Refusal of Planning Permission

Reference: H16-0330-15 **Received:** 14th April 2015

Description: Alterations to elevation to change window to door

Location : THE STATION GATES 4 WINSOVER ROAD
SPALDING

Revised elevation

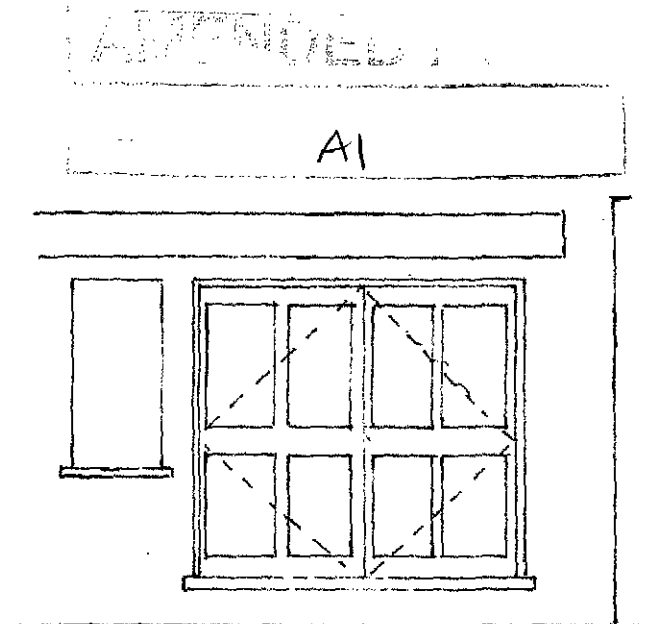
- 1 The ground floor of The Station Gates would be significantly undermined by the replacement of the present window with a pair of double doors by virtue of upsetting the pattern of fenestration, and creating architectural ambiguity in relation to the traditional public house entrance. The proposed alterations to this late Victorian former public house would cause unacceptable harm to both the traditional character of what is a prominent traditional building, and the wider Spalding Conservation Area to which it is adjacent. The proposal is therefore contrary to national guidance contained in Section 12 of the National Planning Policy Framework, 2012, which seeks to conserve and enhance the historic environment.
